APPROVED
 Limited building only review
 Permit holder responsible for full compliance with the code

01/04/2024

**RYAN BEACHAM
 RESIDENCE**

**2ND FLOOR PLAN**

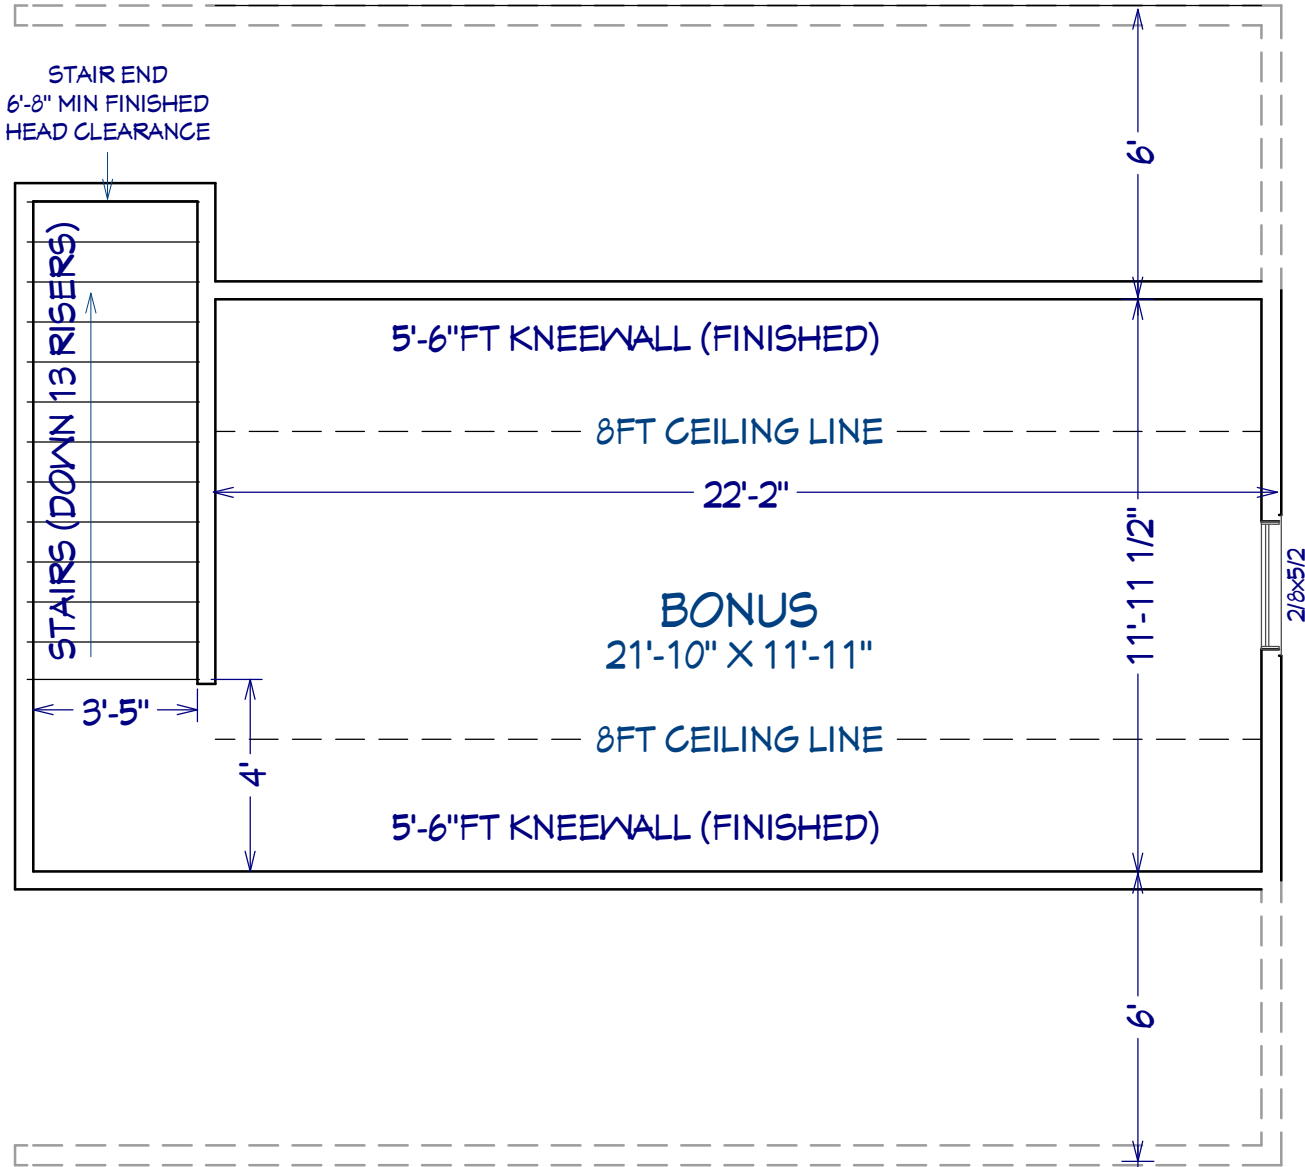
See notes about bonus room stairway

This area will be extremely tight for headroom as drawn. The 3x3 landing at top and bottom of stairs must be minimum 6'8" headroom, without exception. All areas of the stairway must also be minimum 6'8" headroom, including doorways and cased openings.
